Client	Persimmon Homes		
Project Title	Dappers Lane, Angmering	Project No	20079
File Reference	20079/docs/civils/planning/discon/TN01		
Prepared By	S.Marshall	Date	22 October 2021
Subject	Discharge of ADC A/76/20/PL Conditions 18, 19 and 21	Revision	-

This Technical Note has been prepared in response to an ADC (Arun District Council) Drainage Engineer request for further information/clarification¹.

Drawing Status	CONSTRUCTION
Scale	A1
Date	October 2020
File	20079/dwgs/civils/current
Drawn	LJ
Checked	
Drawing	
20079 - 326 E

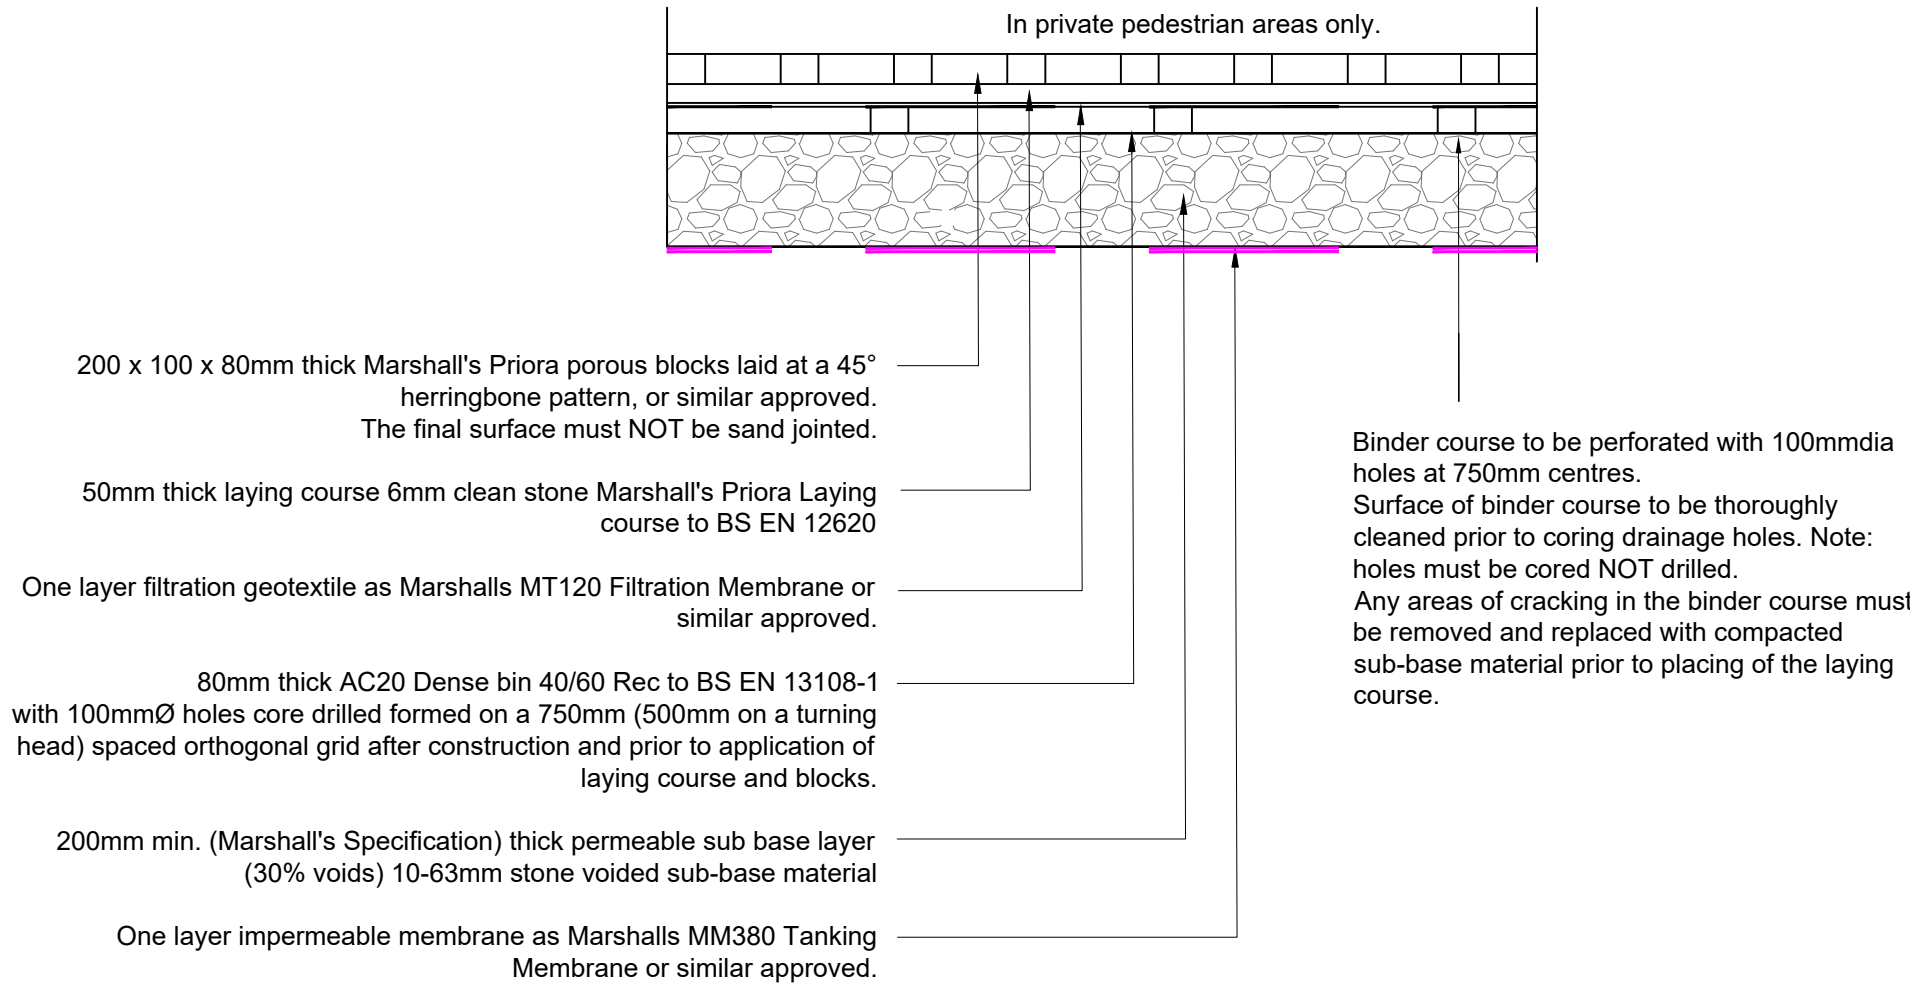
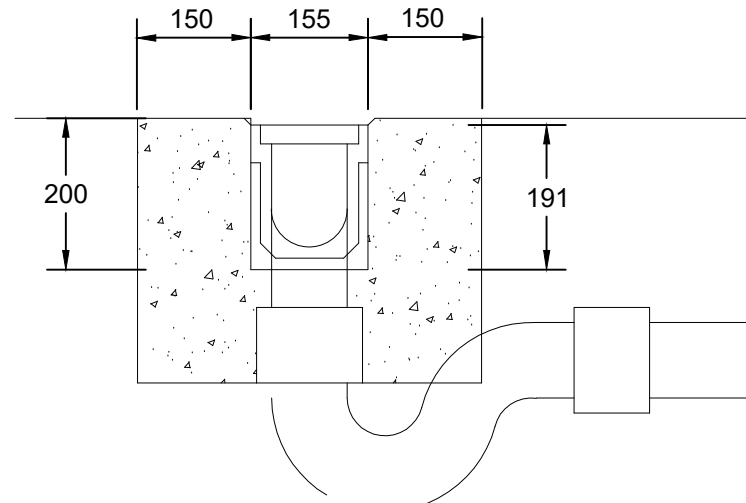
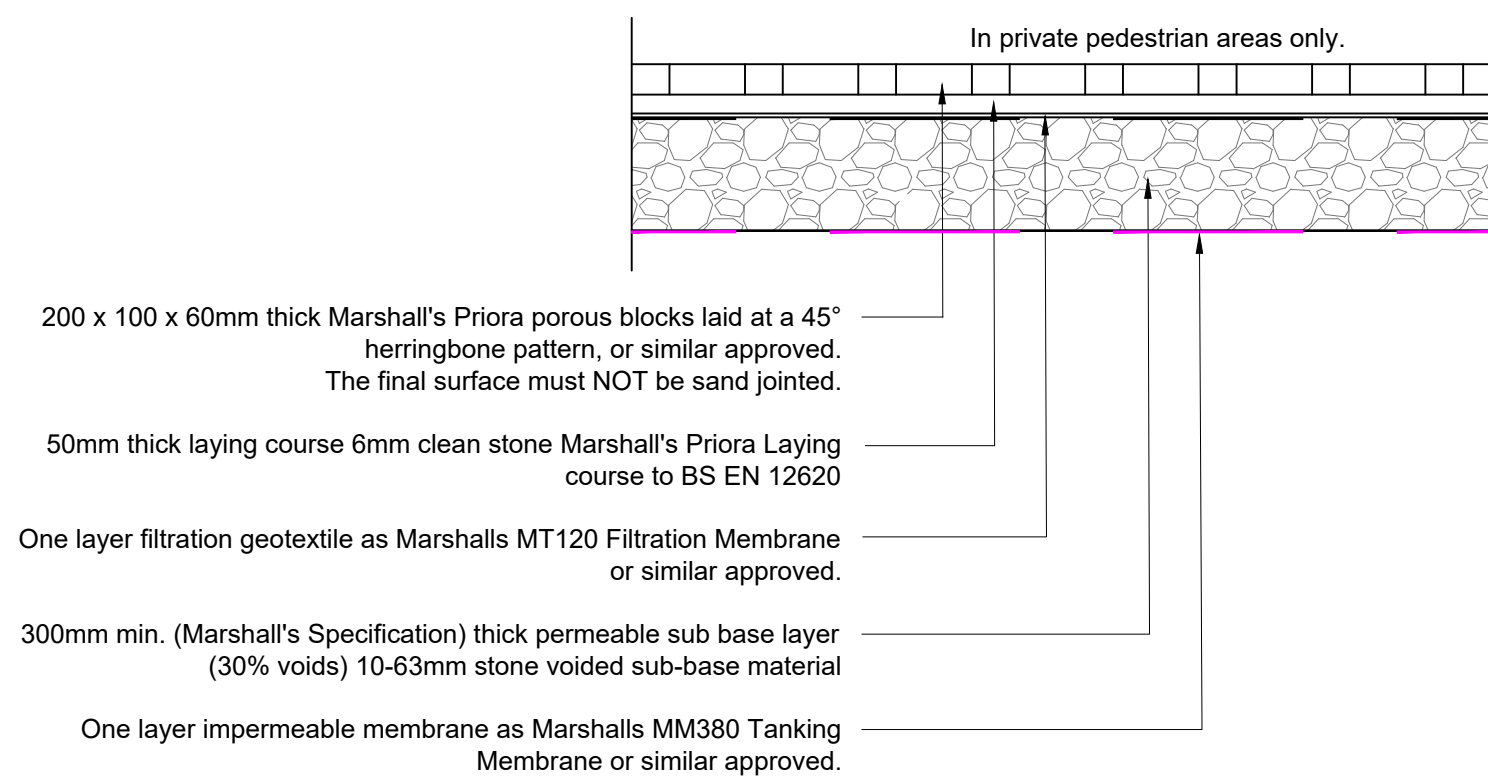
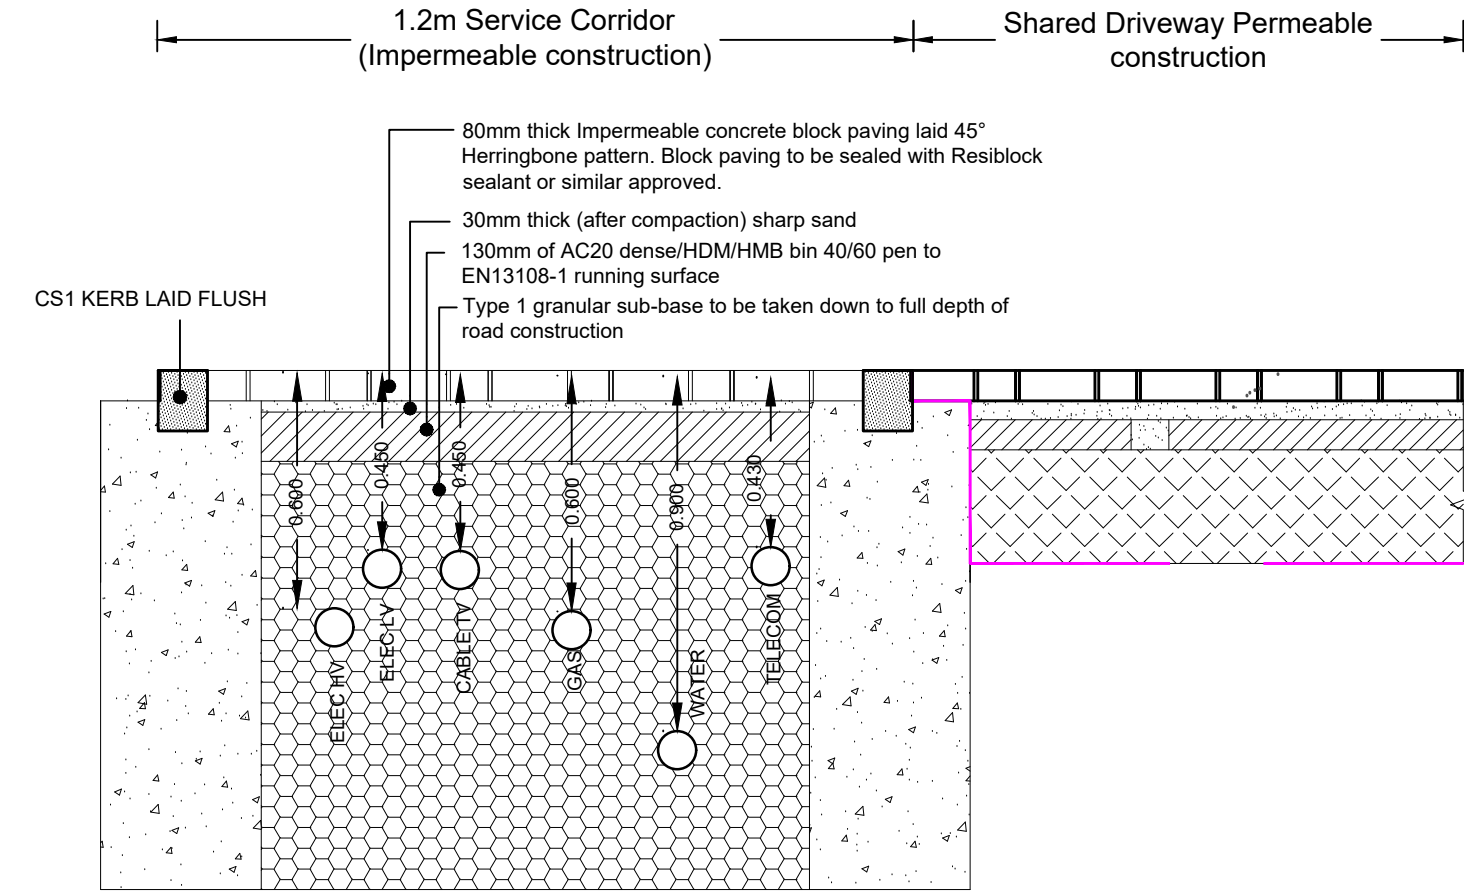
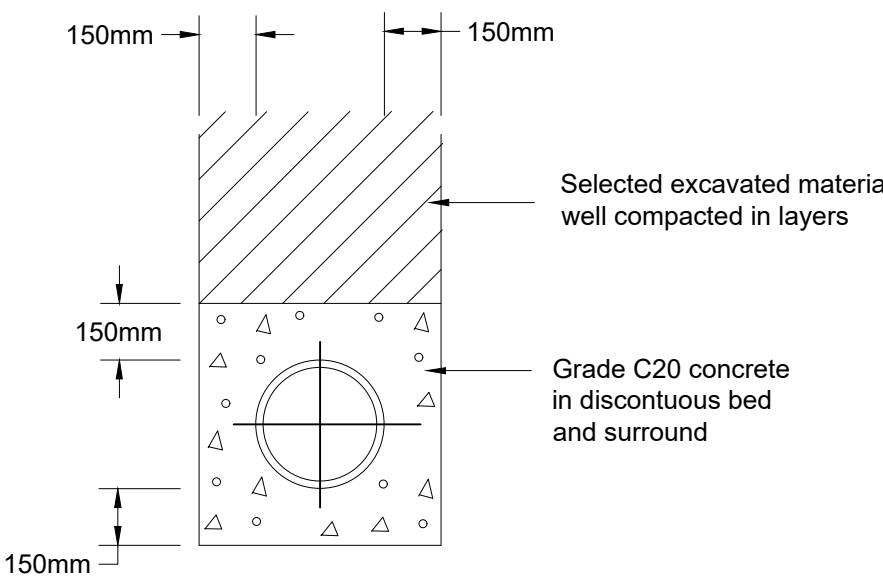
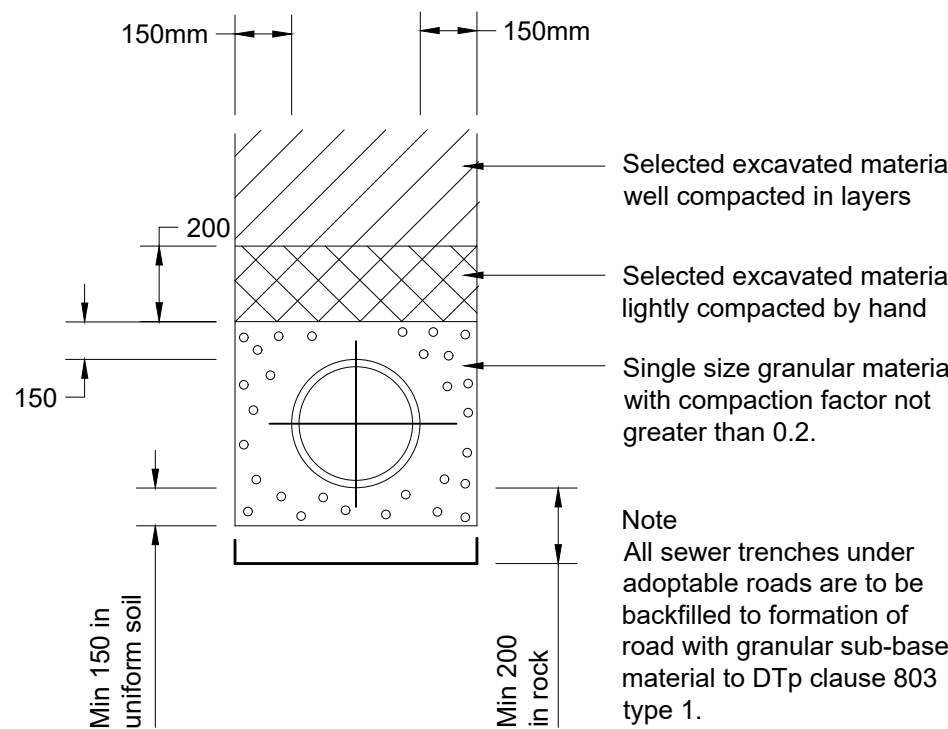
~~Please detail what bed and surround requirements are for pipes outside of adoptable highways. – Bed and surround detail added to private drainage details. Apologies, this only appears to show class S bedding, are you confident that cover depths everywhere within private extents are sufficient to not require concrete bed and surround?~~
